City of Albuquerque

RE: GRADING & DRAINAGE PLAN FOR PUEBLO BONITO CAFE (J-13/D54)
RECEIVED DECEMBER 27, 1993 FOR BUILDING PERMIT APPROVAL
ENGINEER'S STAMP DATED 12-23-93

RE: GRADING & DRAINAGE PLAN FOR PUEBLO BONITO CAFE (J-13/D54)
RECEIVED DECEMBER 14, 1993 FOR BUILDING PERMIT APPROVAL
ENGINEER'S STAMP DATED 12-10-93

GRADING AND DRAINAGE PLAN

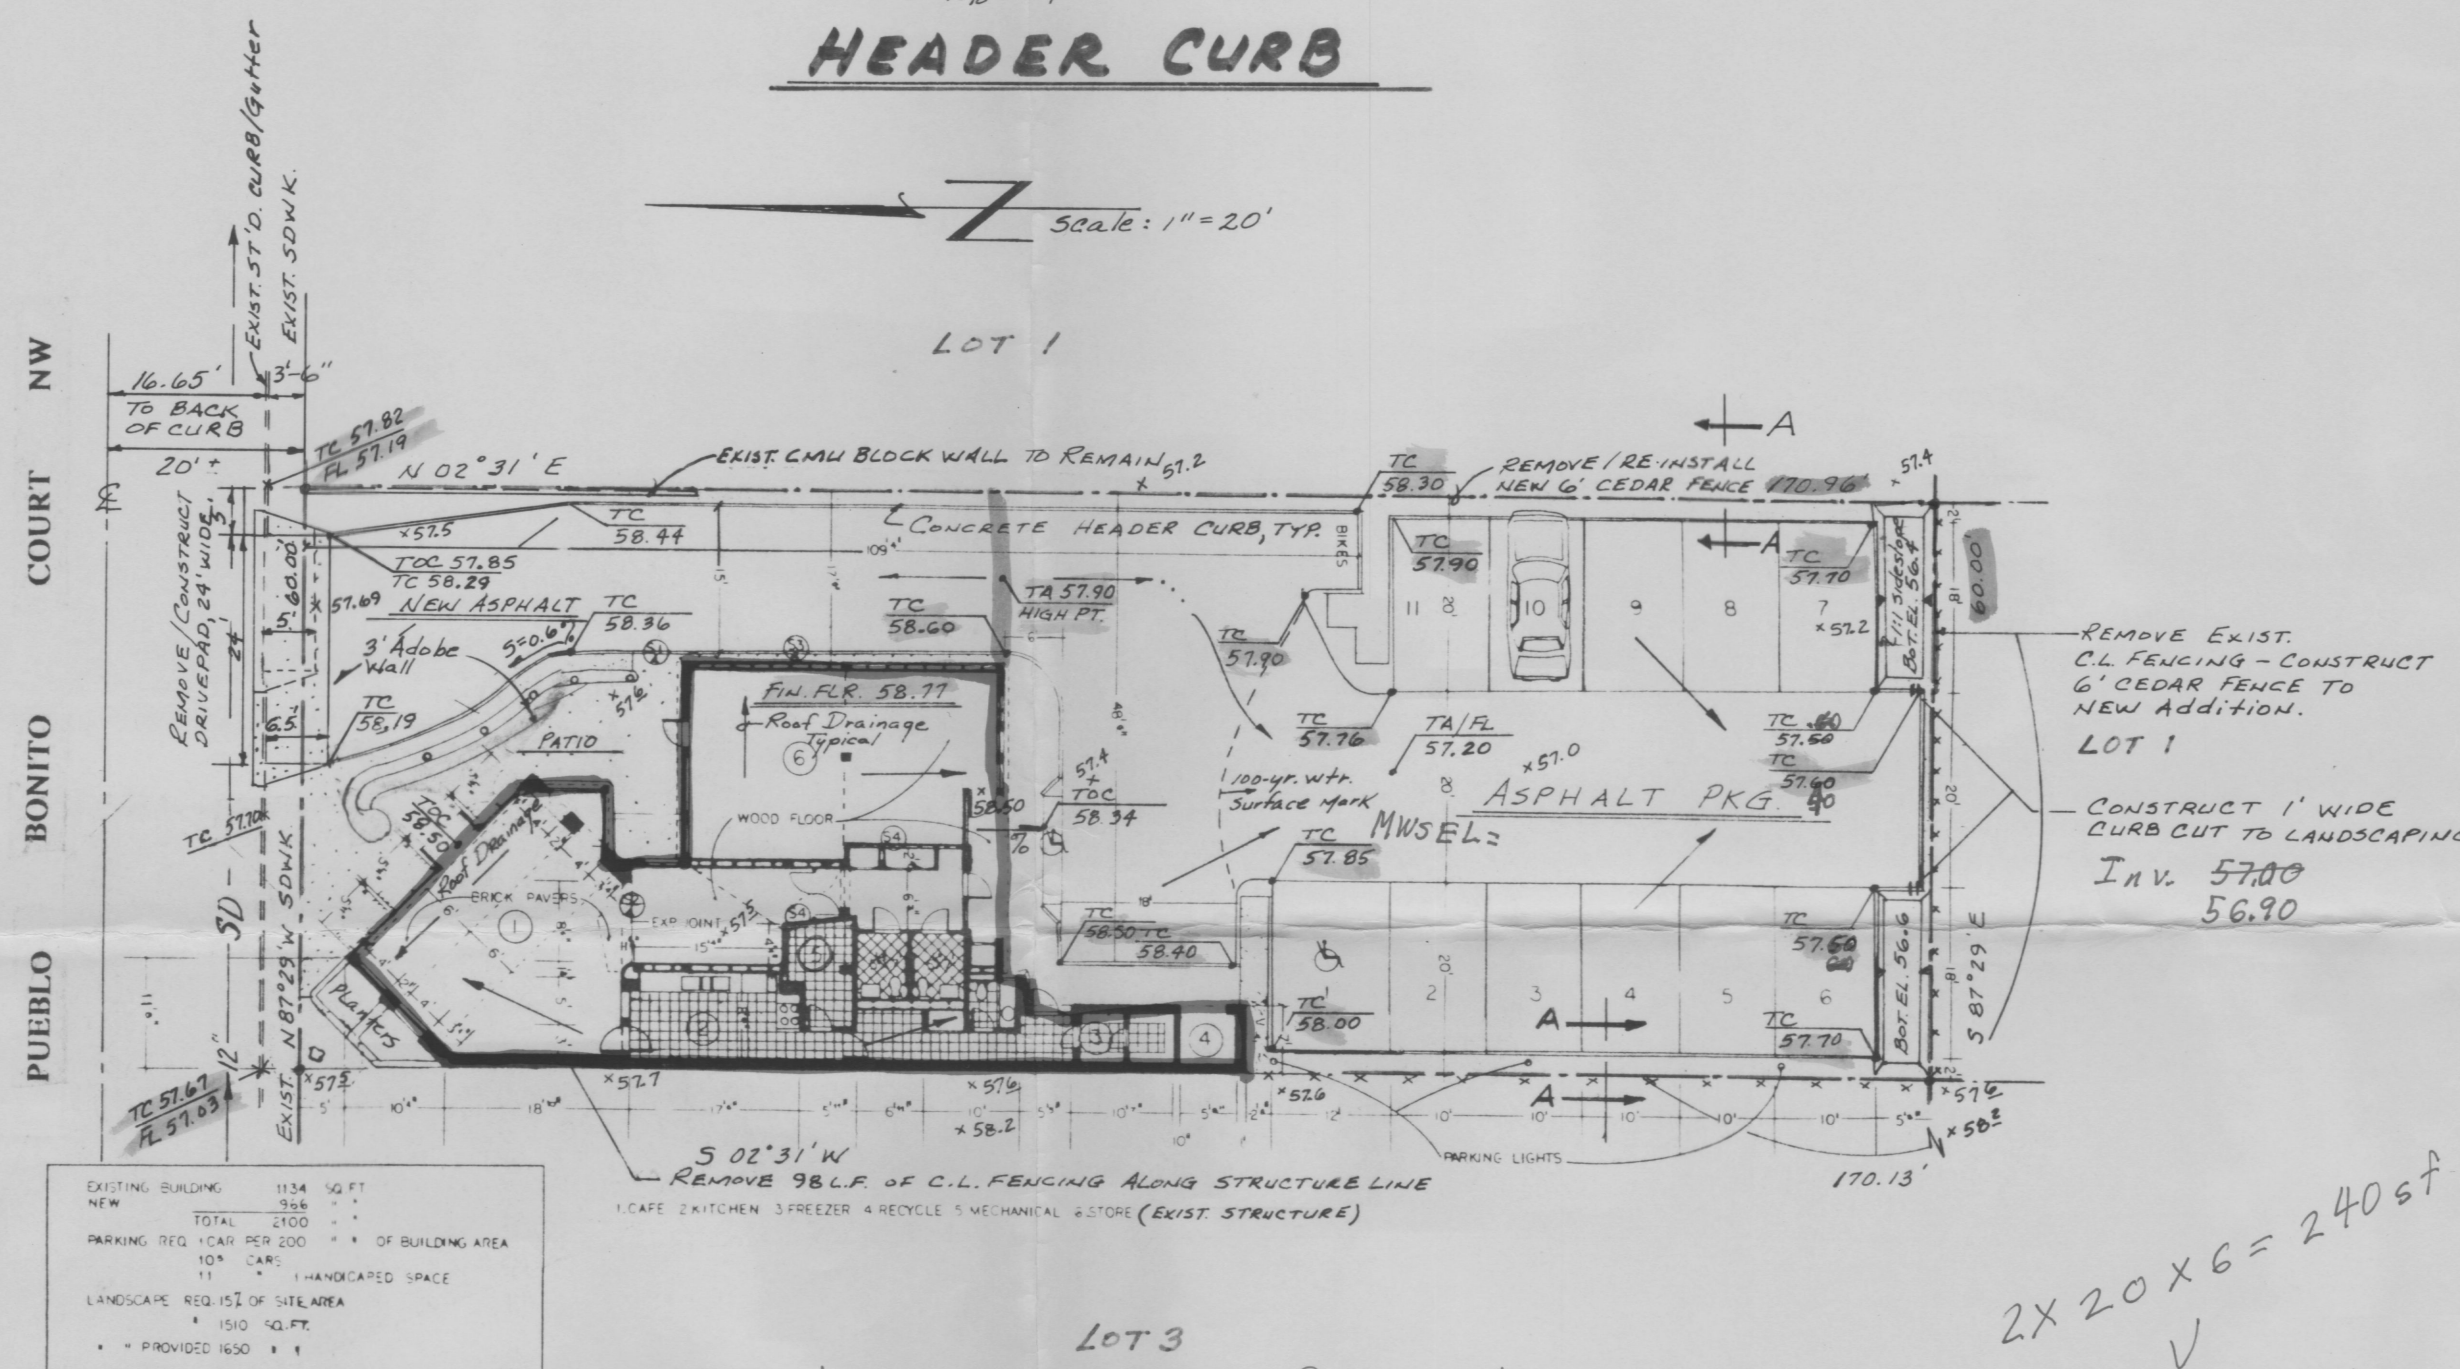
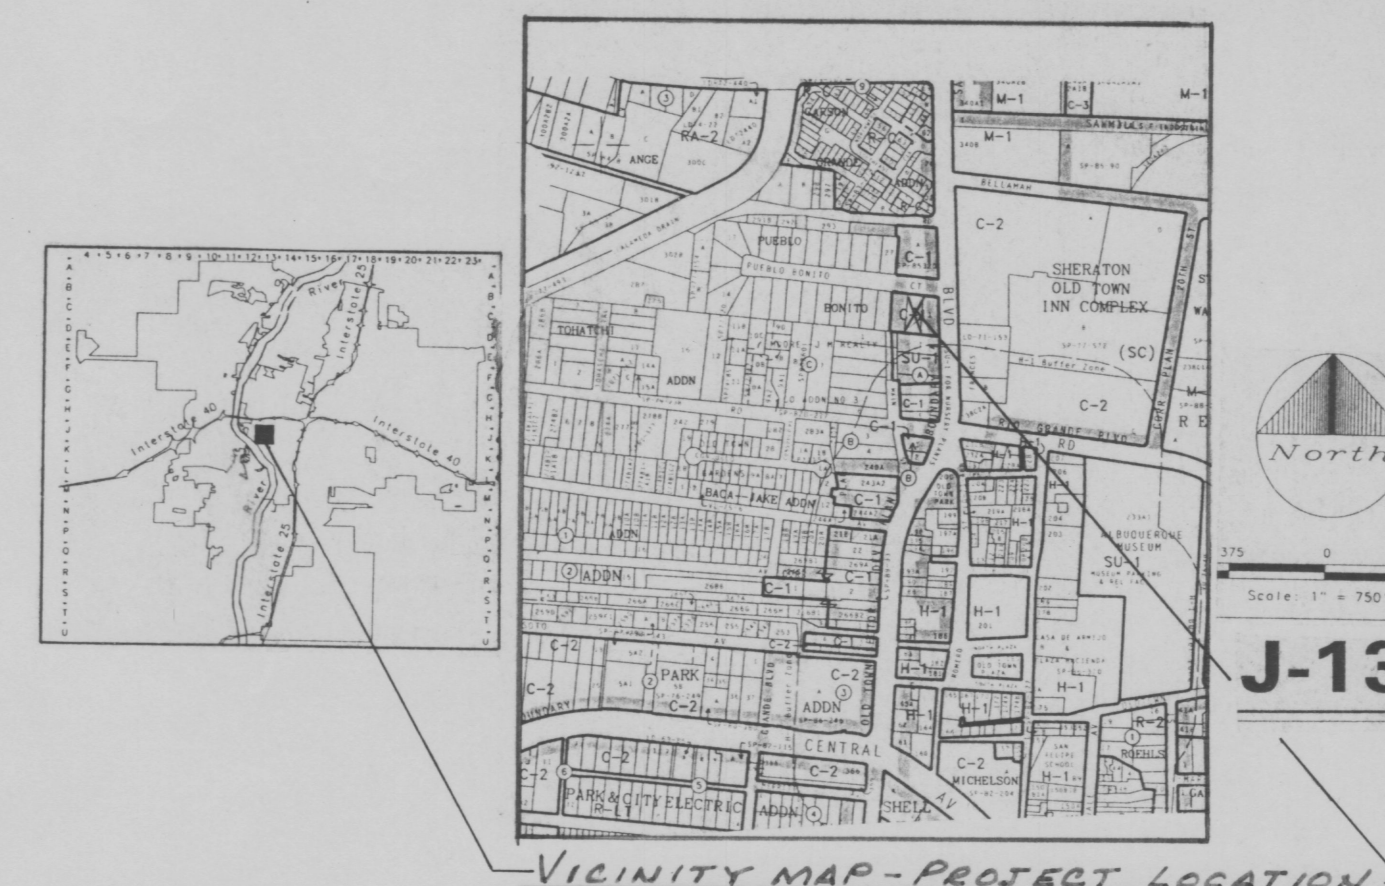
1. The Mayor's Emergency Rule, published 5-14-91, requires that all retention ponds will be designed to contain the 100 year 10 day storm.
2. Indicate the basin boundary between the runoff that drains to the street and that which drains to the backyard pond. Delete the floor plan of the building. It obscures the roof drainage pattern. These revisions should allow a more accurate calculation of the volume required for the backyard pond.

3. Submit detailed calculations of the pond volume provided. Pond volumes have been calculated based on the vertical walls. Due to the slopes of the parking lot the pond will be closer to a pyramid. City Hydrology recommends that slopes steeper than 3:1 be armored to reduce erosion.

4. Ponding water on top of parking lots is very hard on asphalt. To maximize the life span of the pavement, it is recommended that as much runoff be ponded in the landscape areas as possible. Header curbs maybe required along the property line to prevent runoff from spilling over into adjacent property.
